Appeal Decision

Appeal Ref: APP/T2350/W/23/3322801

Pinfold Farm, Preston Road, Ribchester PR3 3YD

- The appeal is made under section 78 of the Town and Country Planning Act 1990 against a refusal to grant planning permission.
 - The appeal is made by Mr A Davies, Alan & Anne Davies Settlement 2014 Trust, against the decision of Ribble Valley Borough Council.
 - The application Ref 3/2022/1180, dated 21 December 2022, was refused by notice dated 13 March 2023.
 - The development proposed is demolition of approved domestic dwelling to new improved energy efficient domestic dwelling.
-

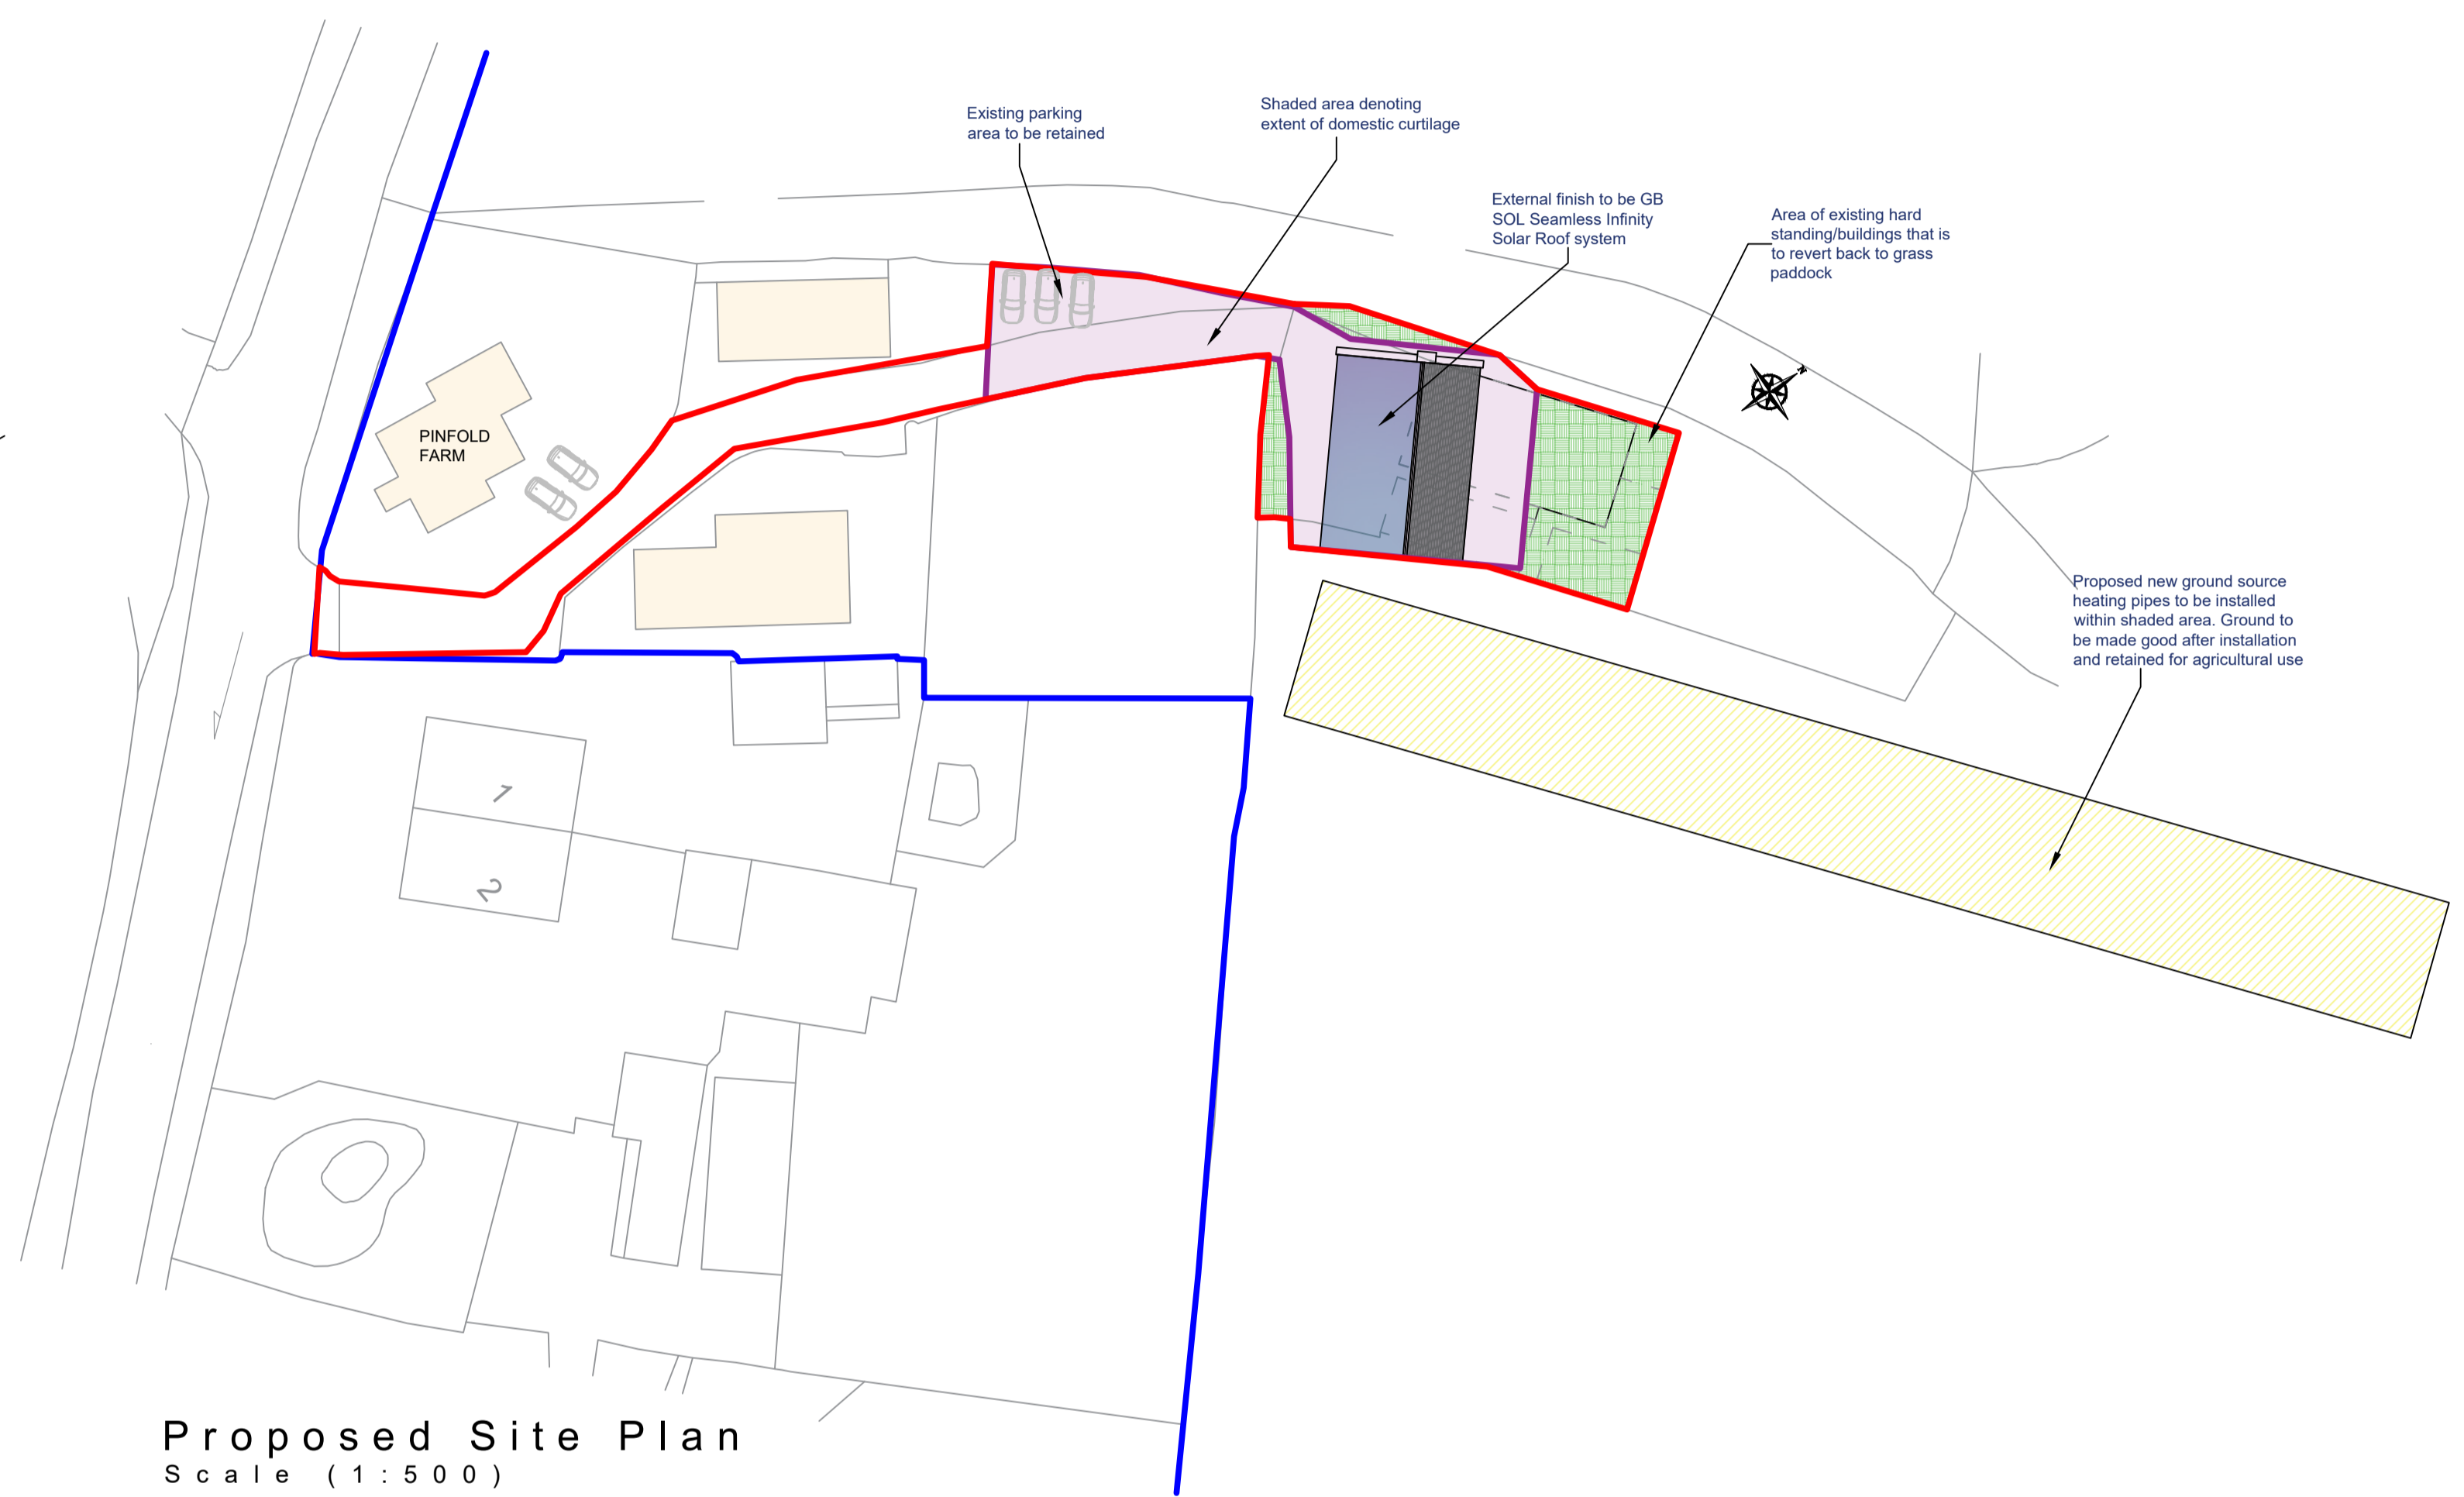
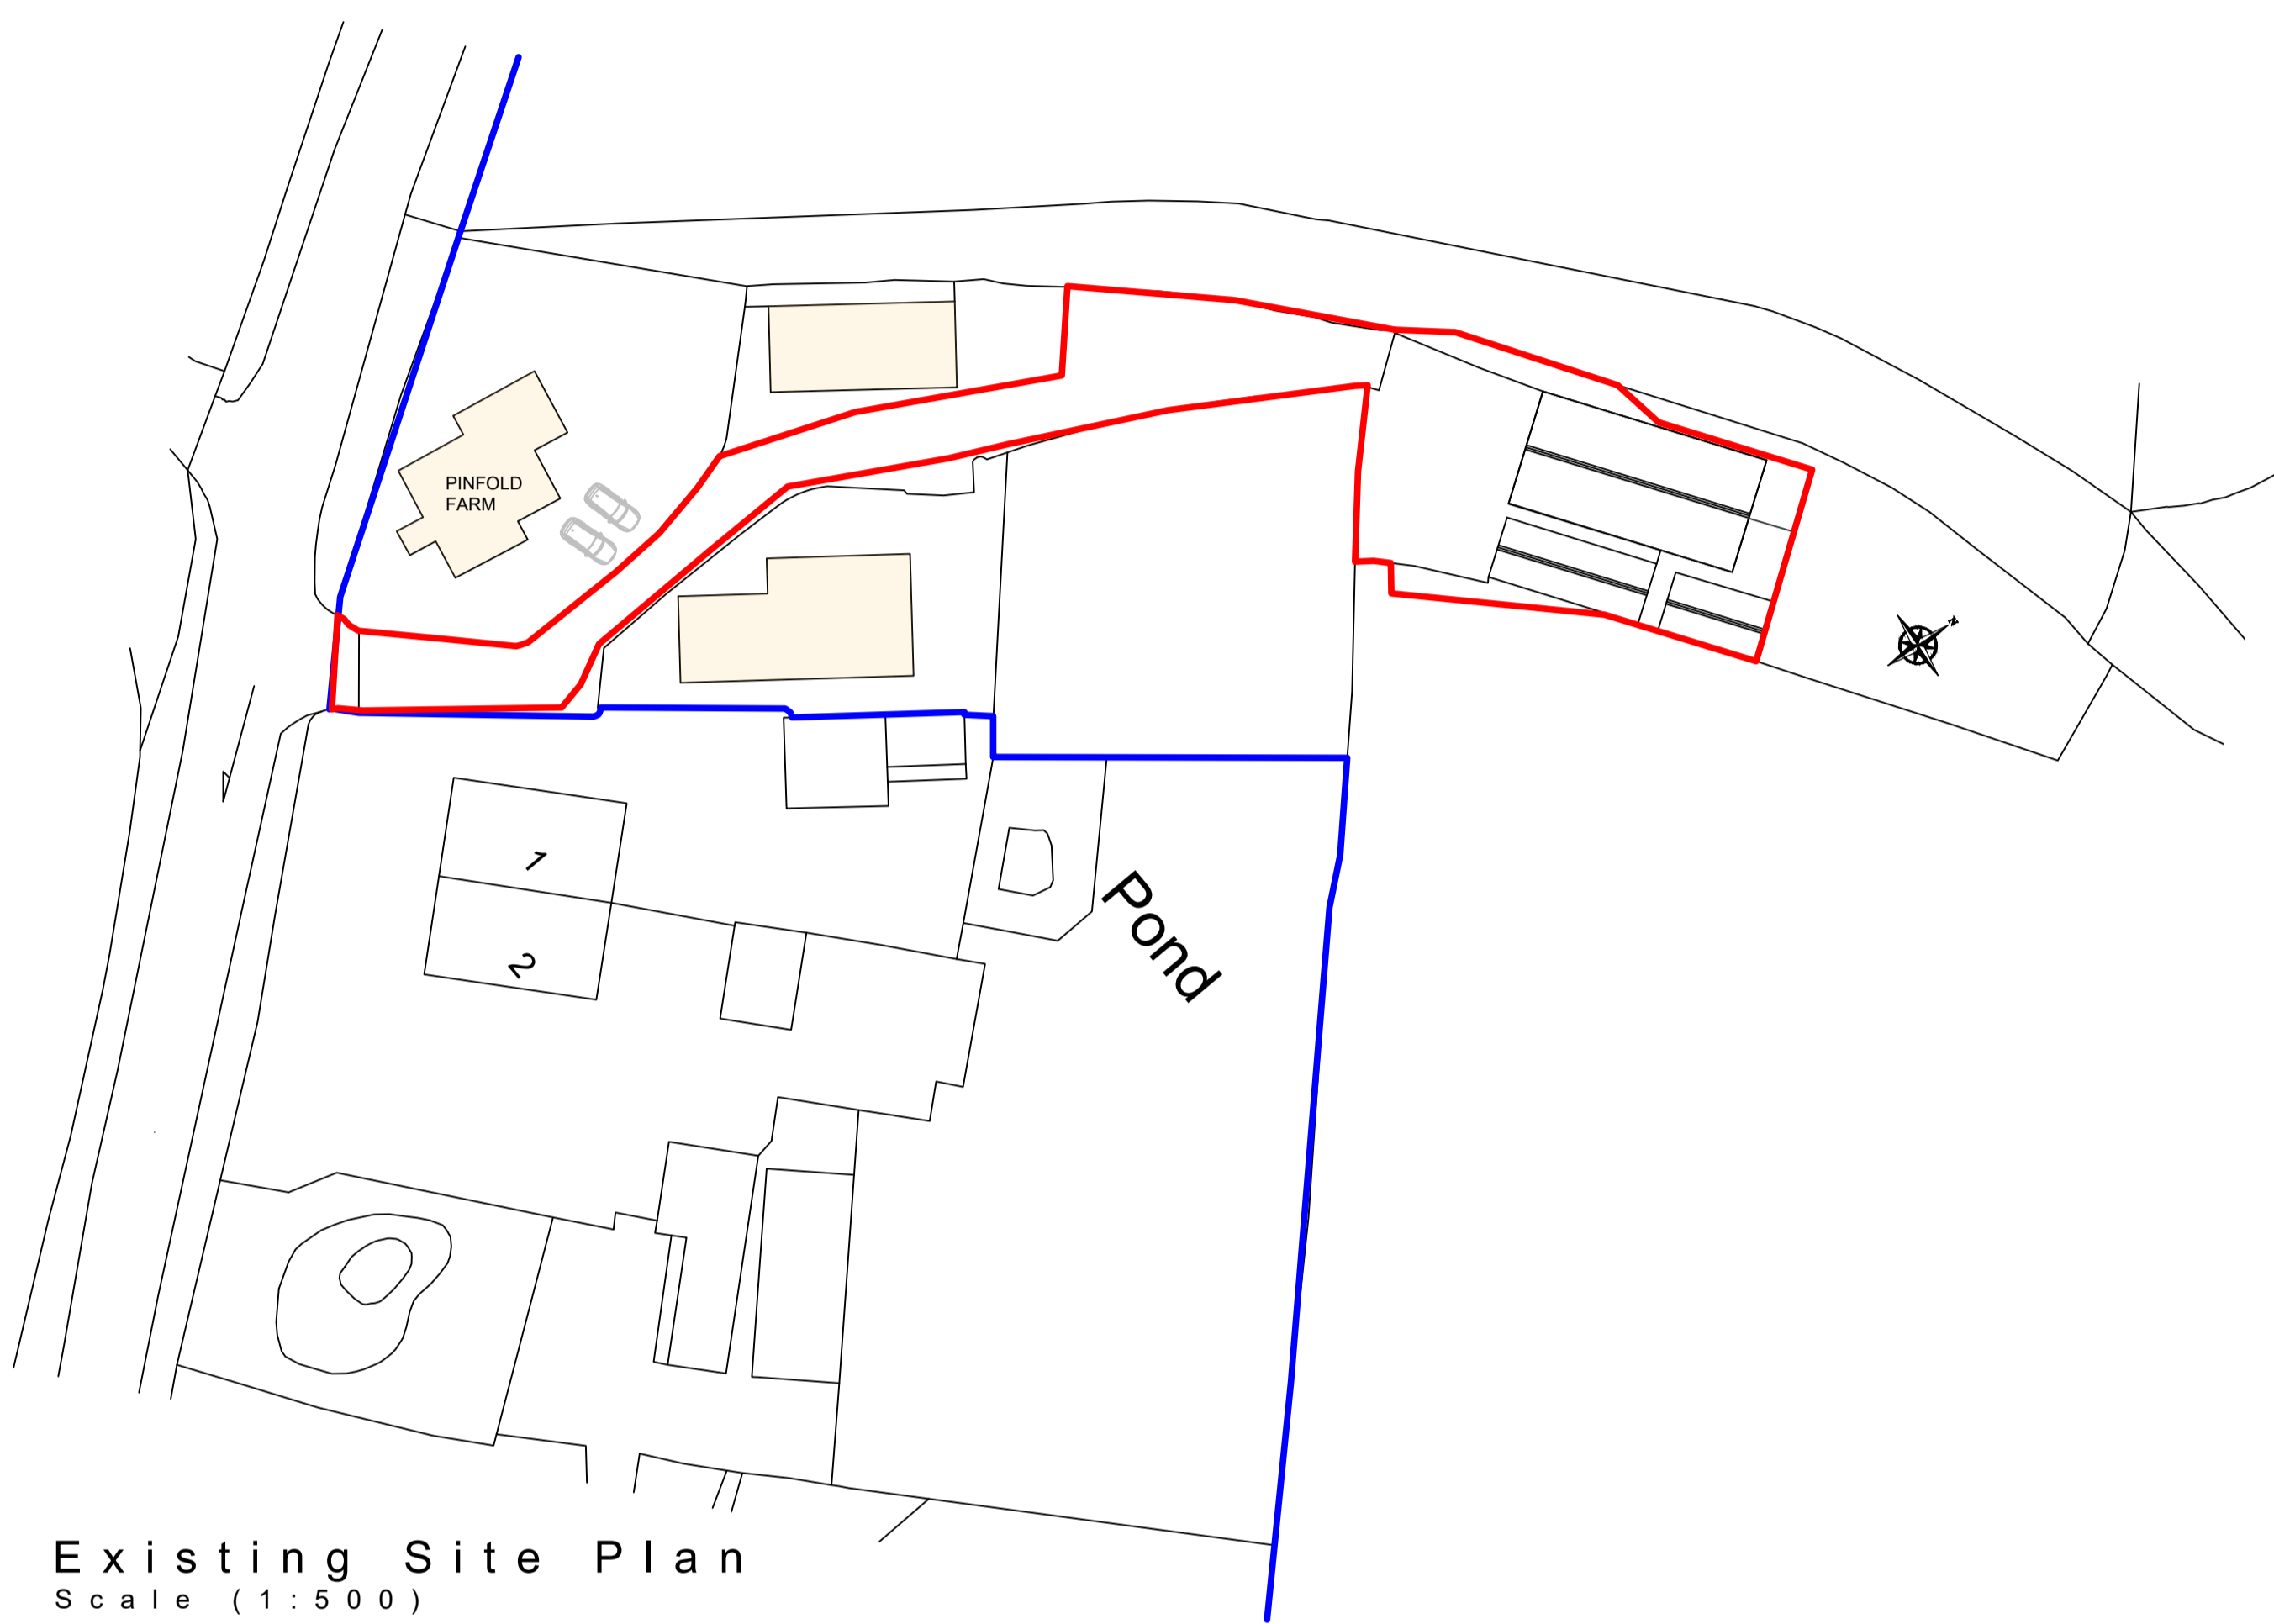
3. For the avoidance of doubt, I have based my decision on drawings Ref: 008 Rev B and Ref: 009, notwithstanding those listed in the Officer's Report. Moreover, it has been clarified that the proposed site plan Ref: 009 does not include hardstanding.

14. The existing buildings are set well back into the site, some distance from the road. The proposed development seeks to demolish these and build a dwelling on a new orientation so that the longest elevation would face the road. This would result in the curtilage being extended on two sides, although this would be reduced to the north where hardstanding would become grass paddock.
